## Application for Removal or Variation of a Condition following Grant of Planning Permission or Listed Building Consent

Demolish outbuildings and erect two storey side extension with garage and single storey rear extension.

2022/1682/HSE

Omit approved planning drawing no. 1580 - 05 and replace with drawing no. 1580 - 11

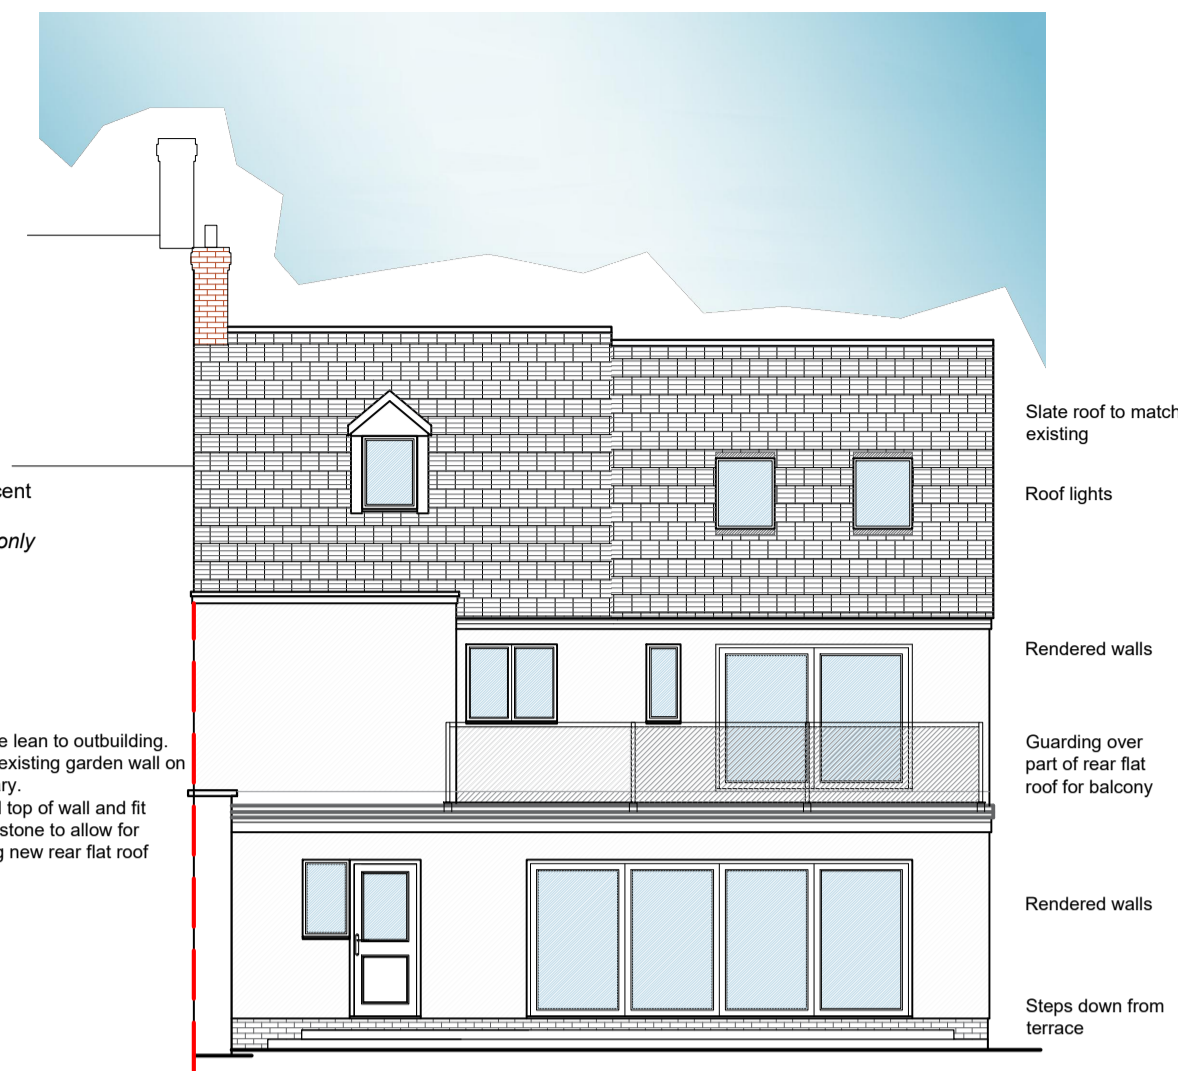
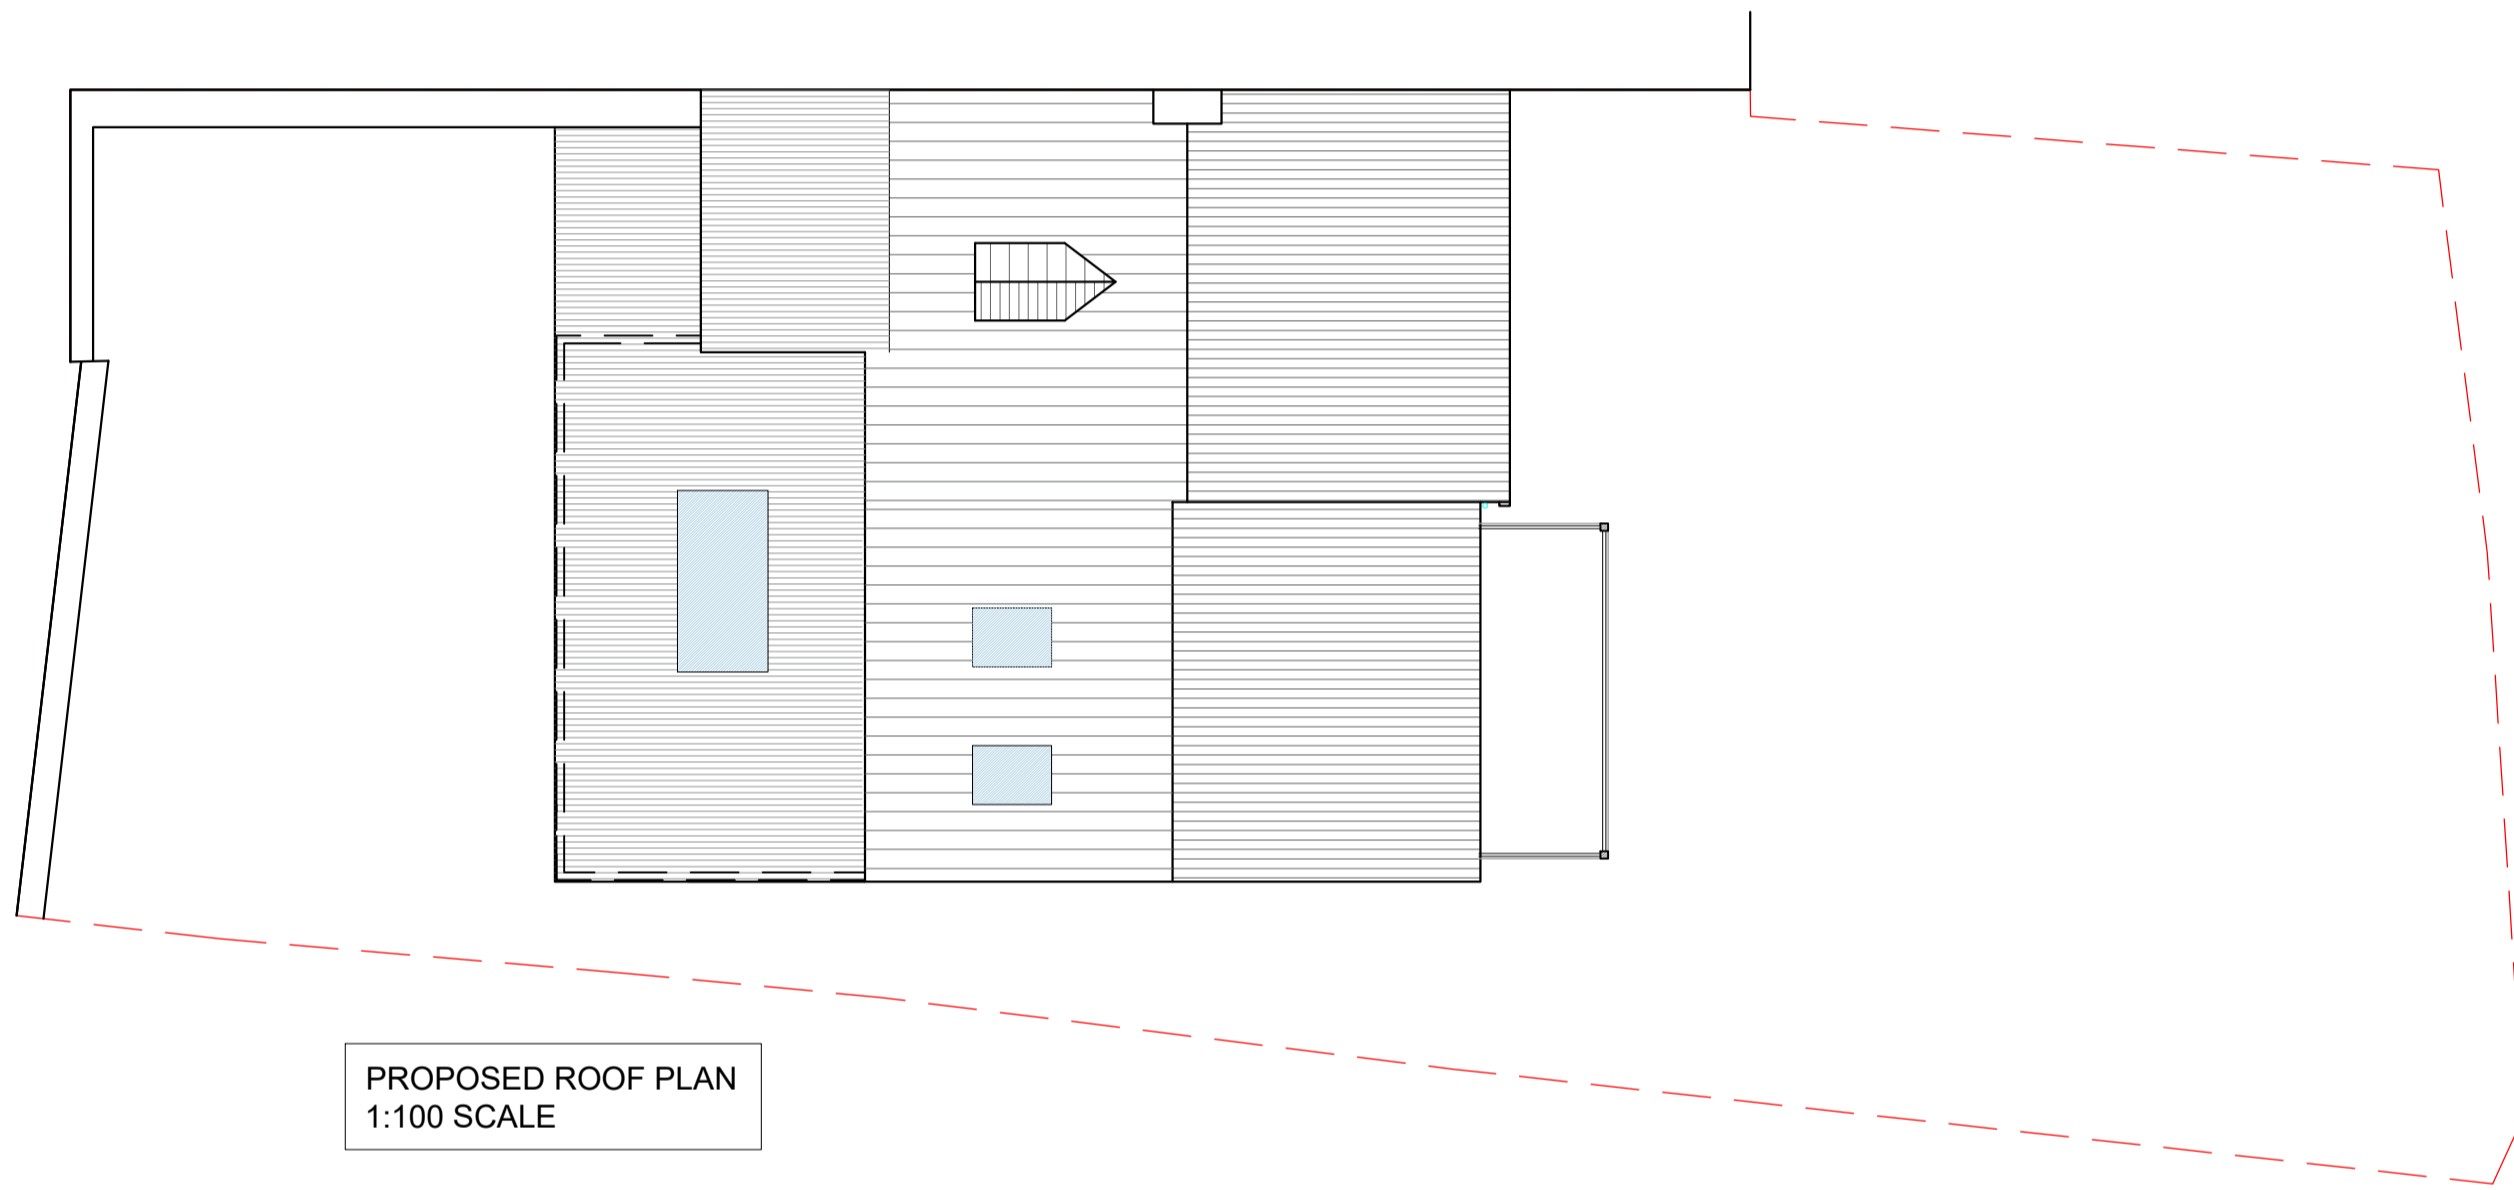
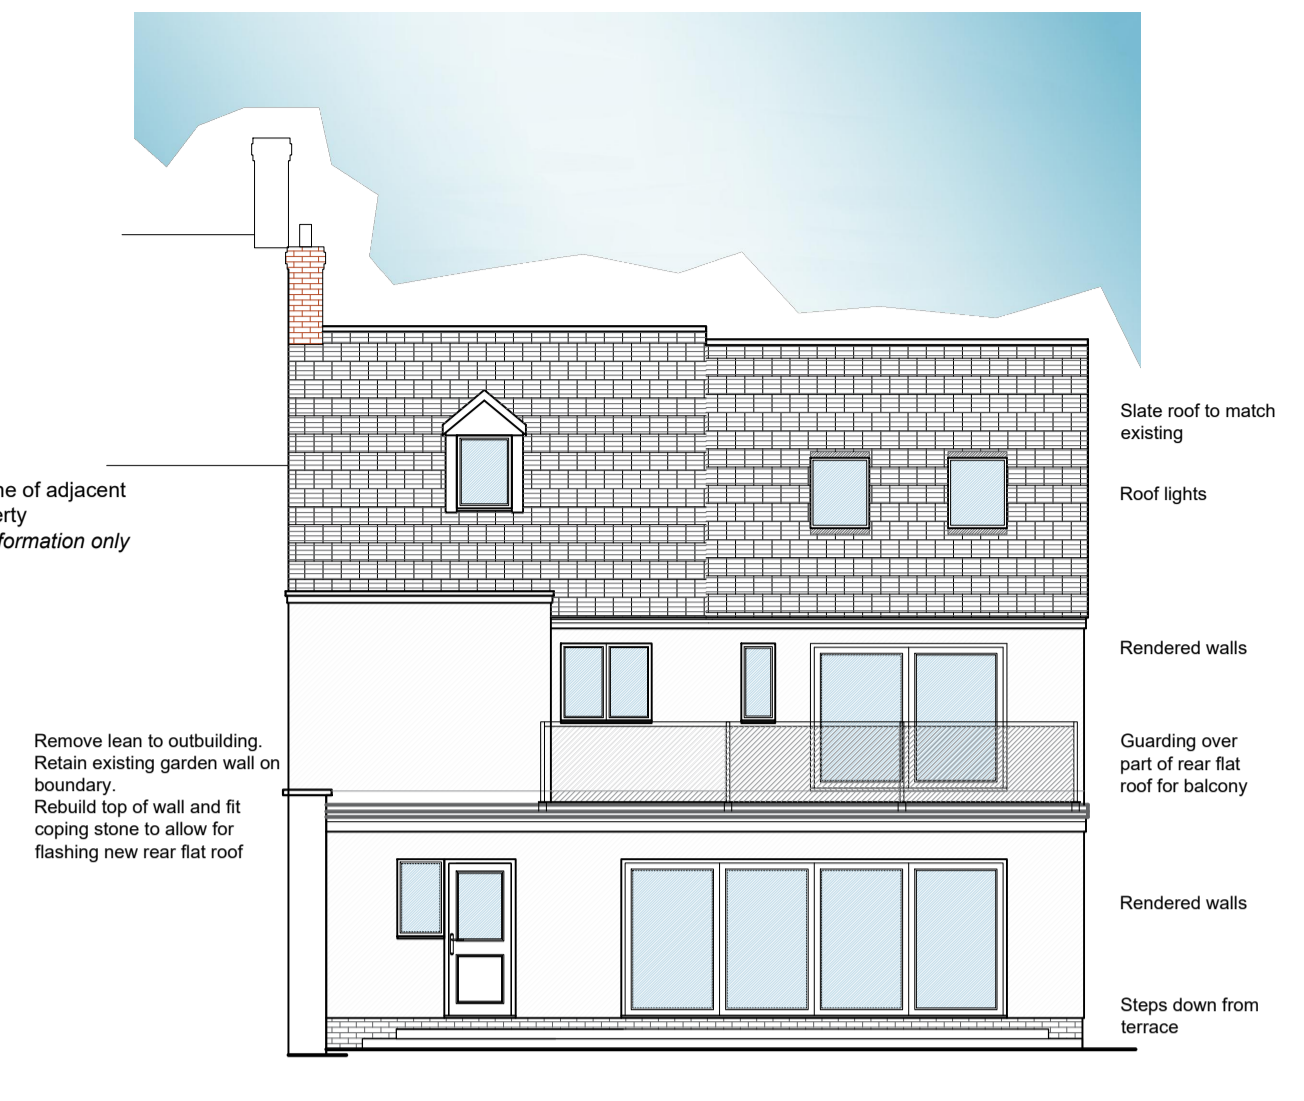
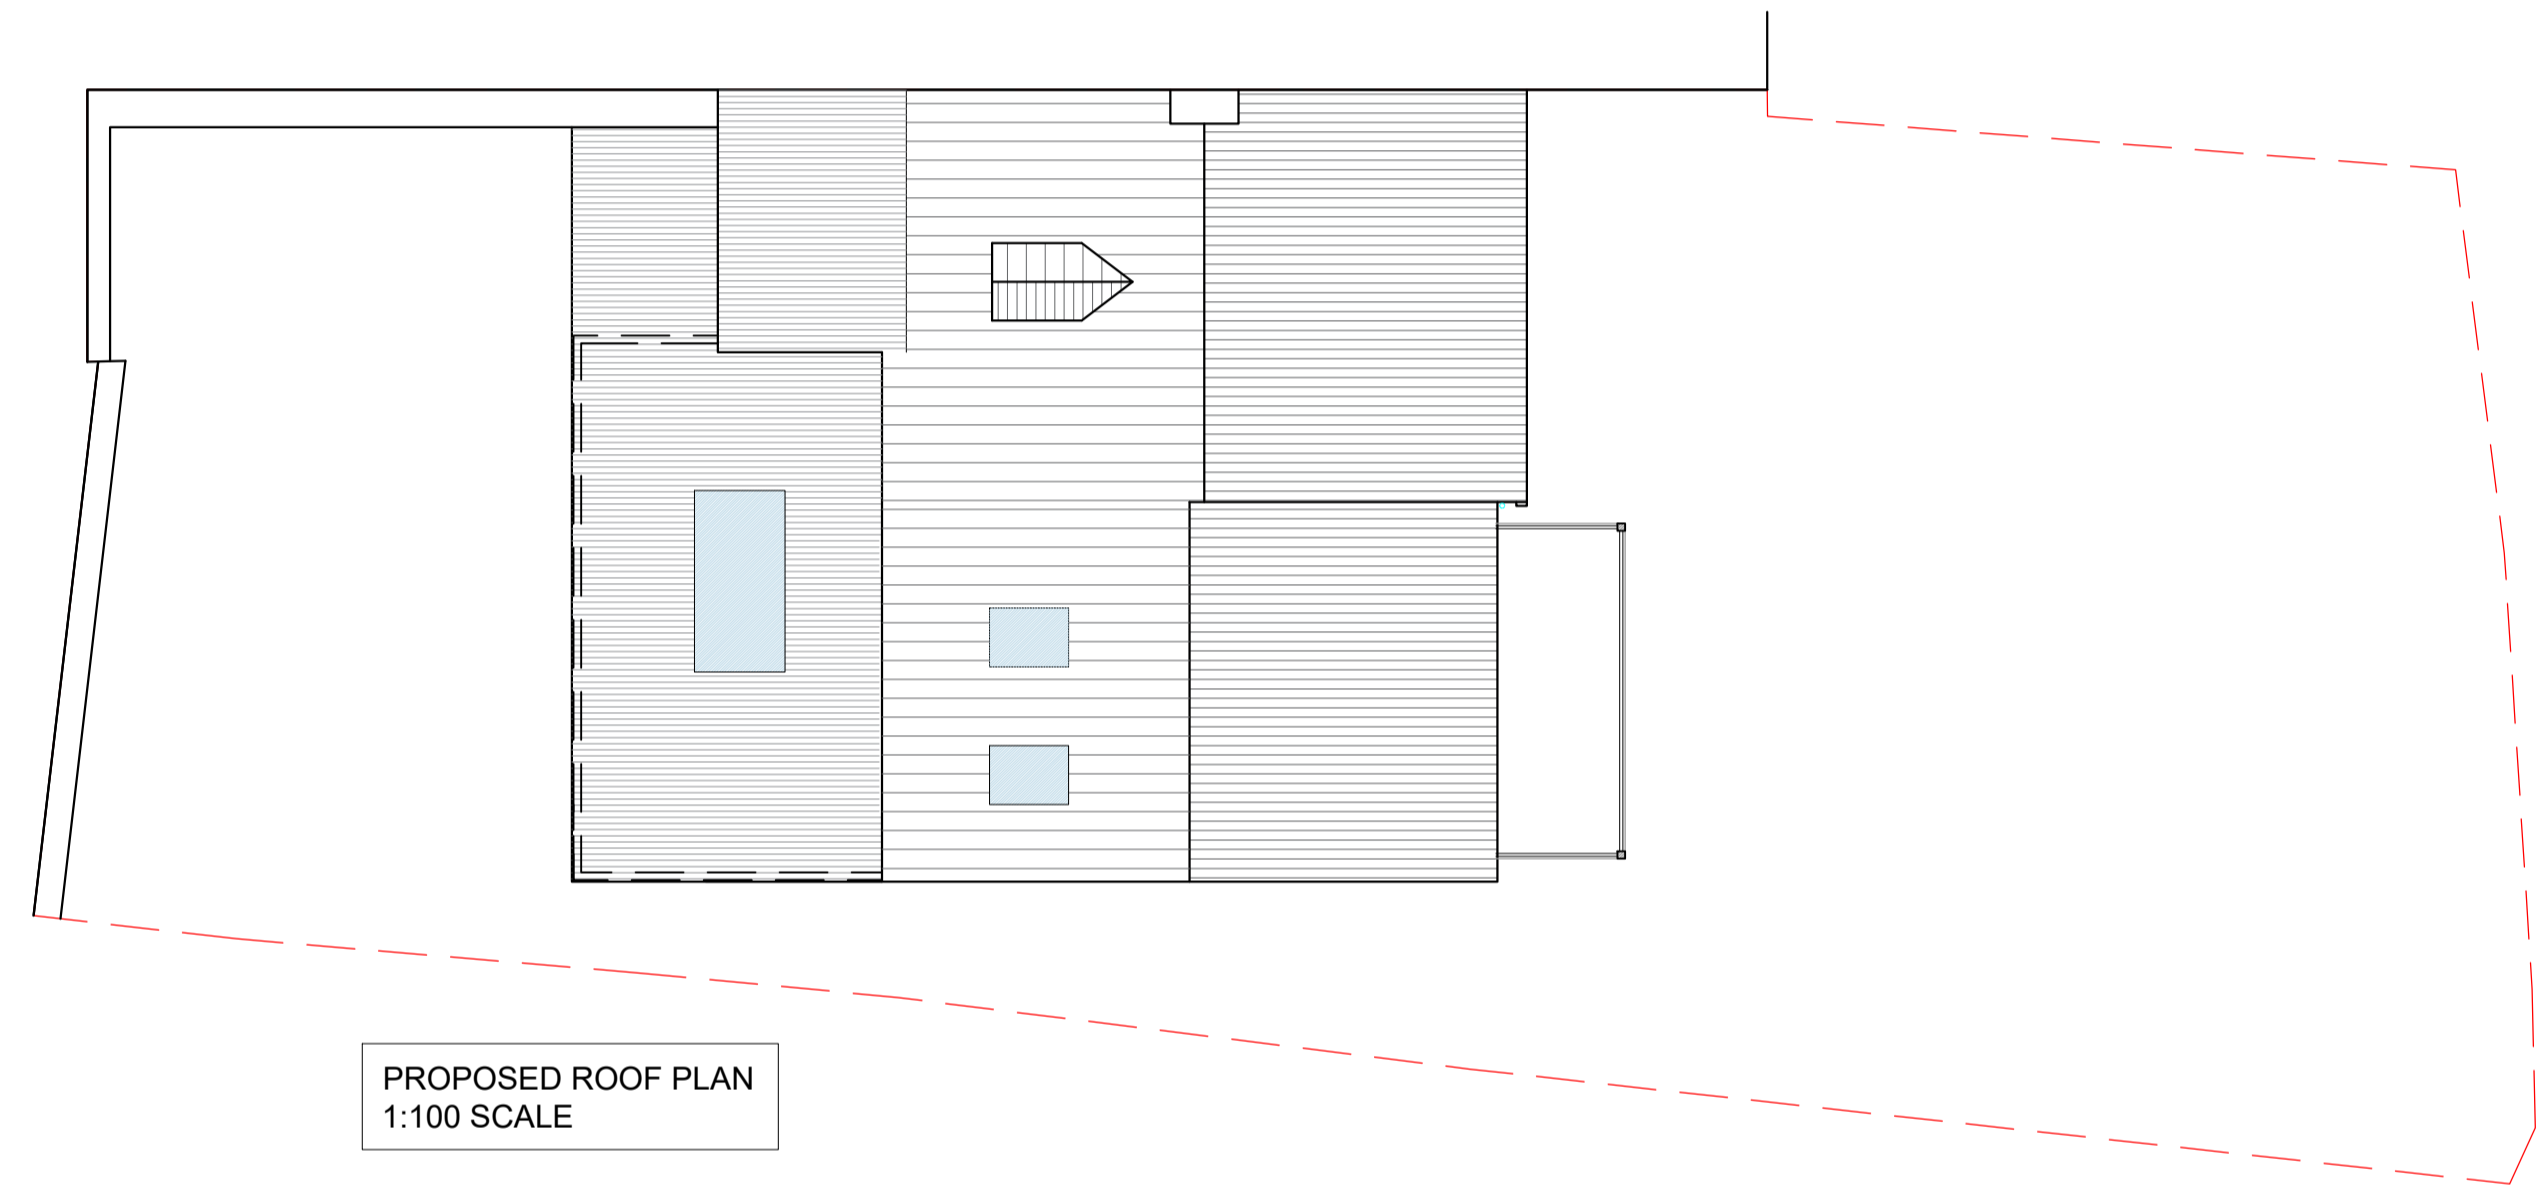
Front elevation render is falling off so now being removed.

Proposal is to retain the stone walls and brick detailing and build front elevation extension wall in materials to match.
